Our Case Number: ABP-313892-22

Re: Bus Connects Blanchardstown to City Centre Core Bus Corridor Scheme
Blanchardstown to Dublin City Centre

Re: Blanchardstown to city centre core bus corridor scheme
Case Ref No ABP - 313892-22

Response on behalf of Giuseppe Vani,
47, Manor Street, Dublin 7
D07 PF 89
Schedule of Commercial Business ref: 107

A2 Existing On-Street Parking Spaces Prussia Street, Manor Street, Stoneybatter and Aghrim Street (between North Circular Road and Brunswick Street North)

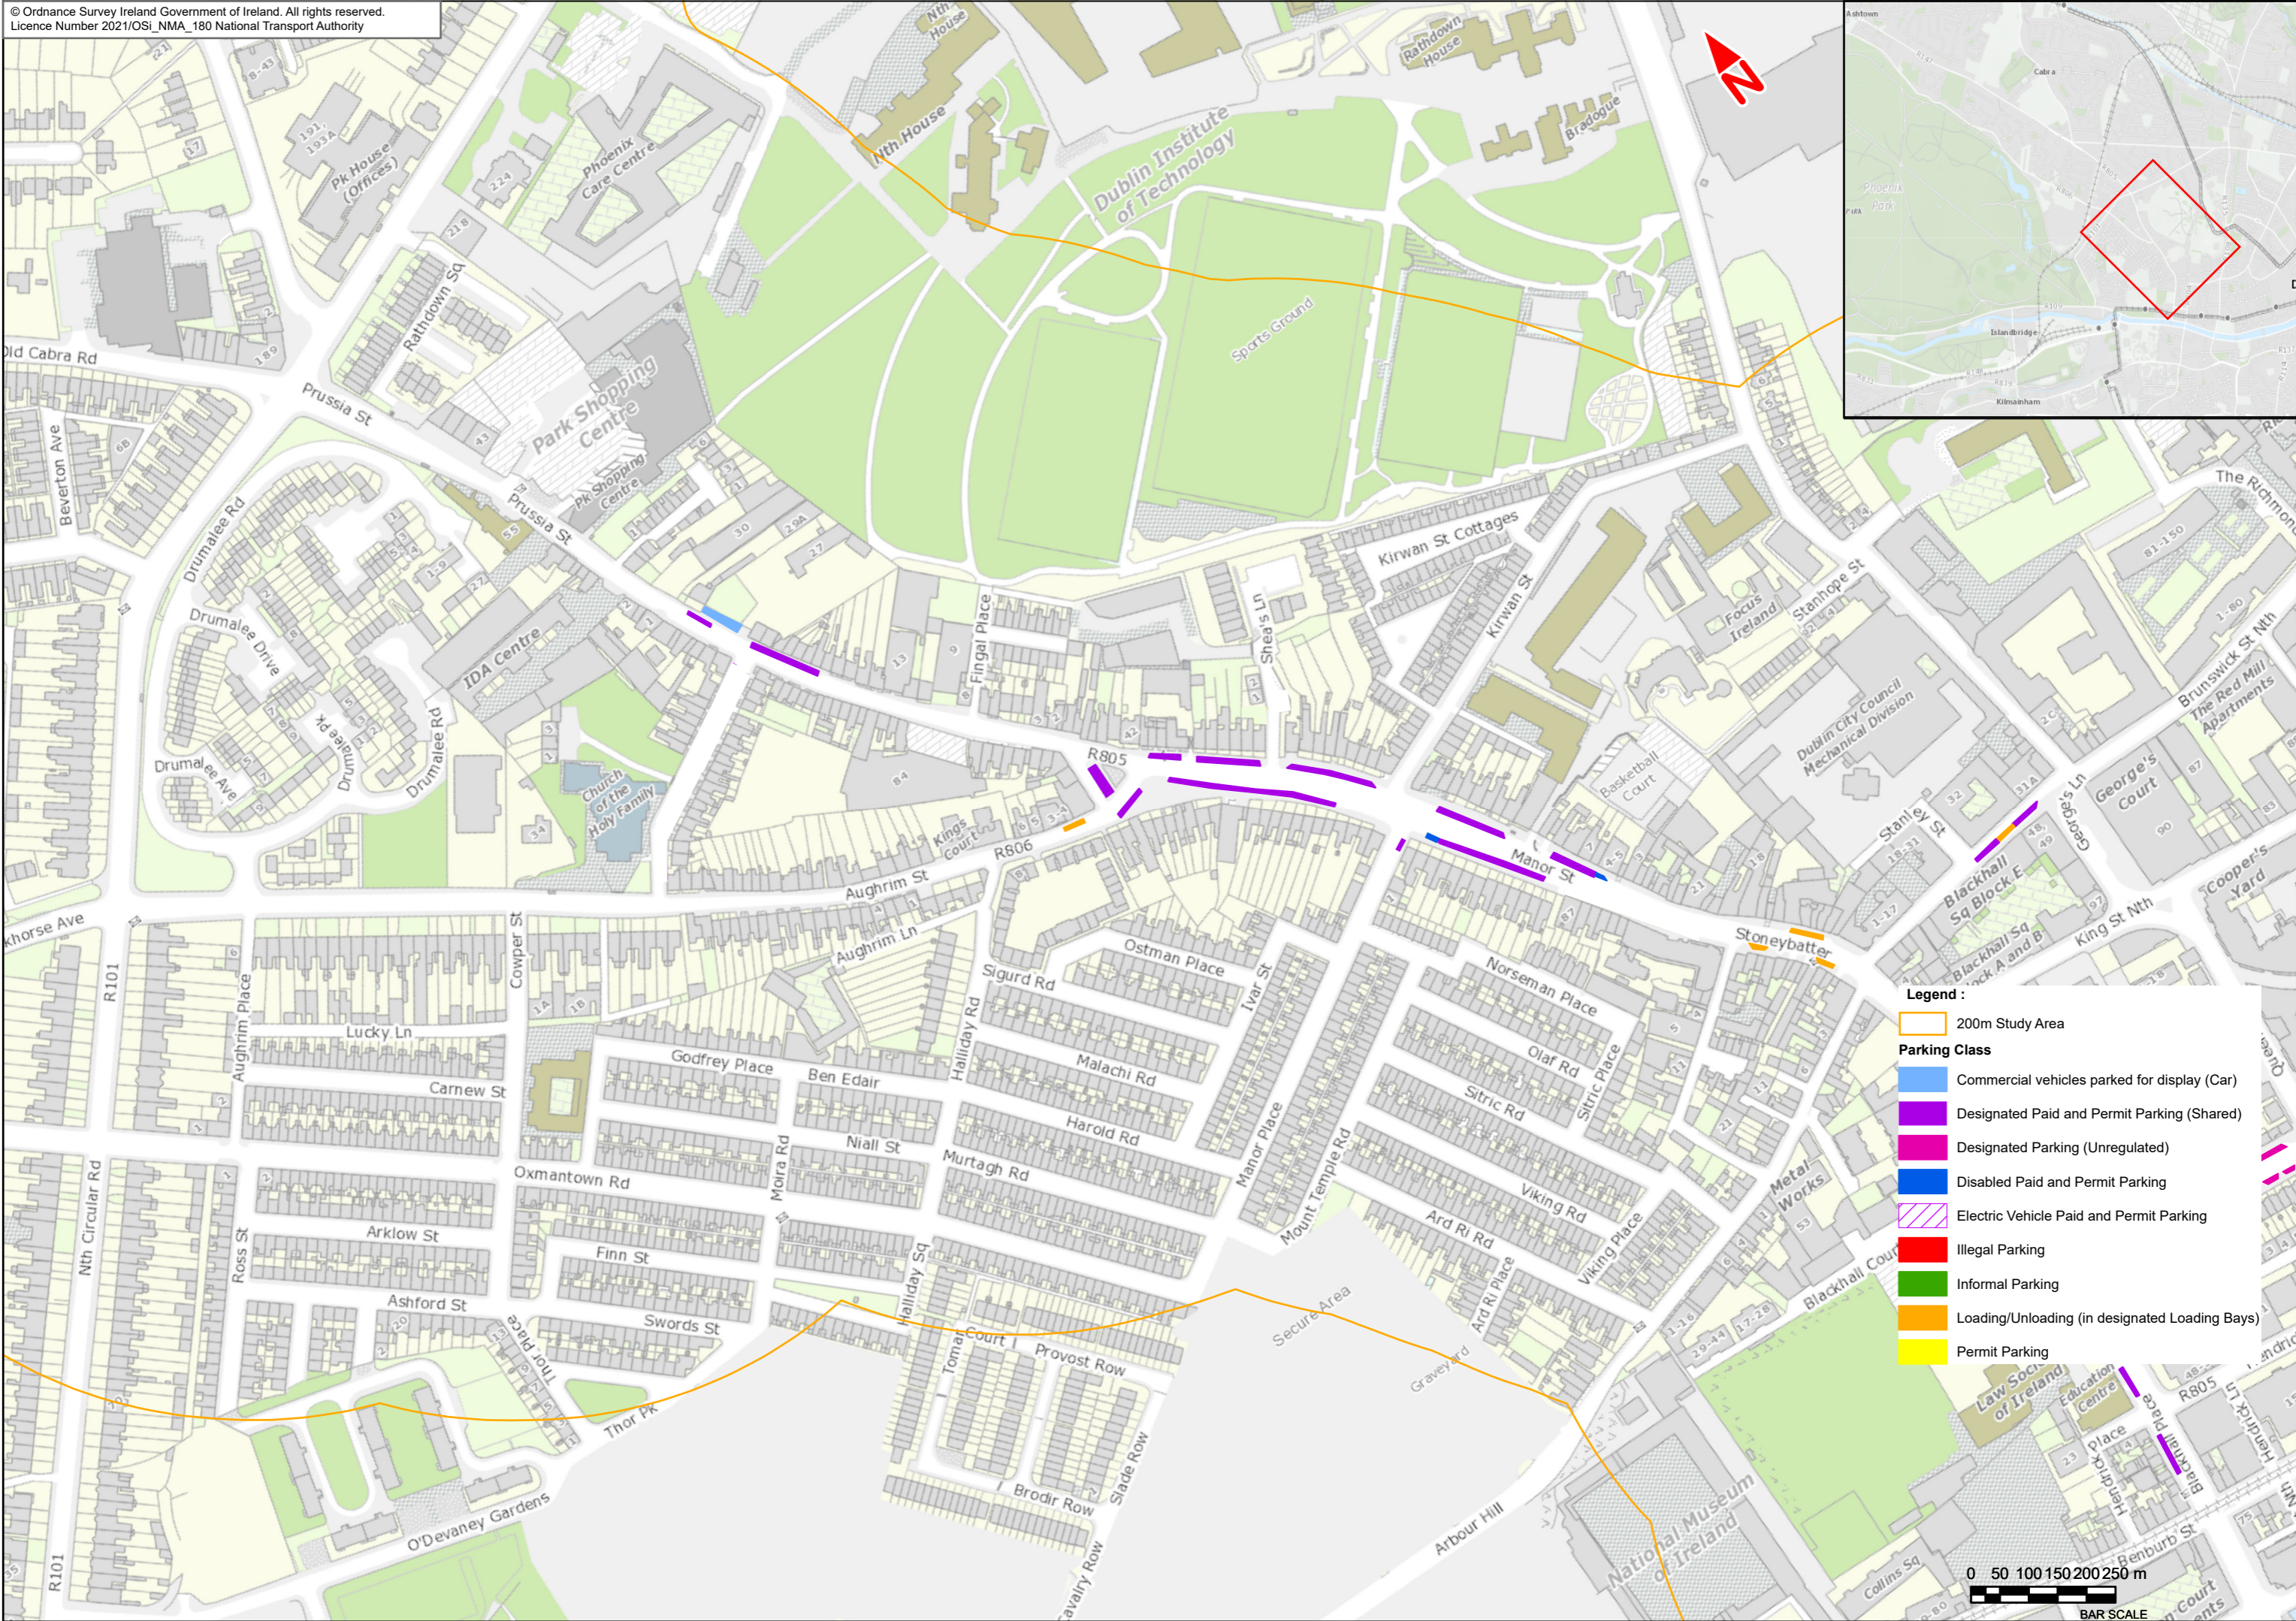
I note from their response that they are aware of our objections but have not addressed our concerns in any way. They have not indicated how my client is to service his business in the absence of any road frontage, loading bays or car parking. As pointed out in our original report the retention of the link road between Aughrim Street and Prussia Street and adjacent car parking will have absolutely no impact on the overall plan and will only impact on the proposal for the 'Stoneybatter Plaza'.

I would ask you therefore on behalf of my client, at the very minimum to retain the link road and adjacent car parking and the existing arrangement which works very well. There will still be room for public plaza but at a distance from the public house and Take-Away.
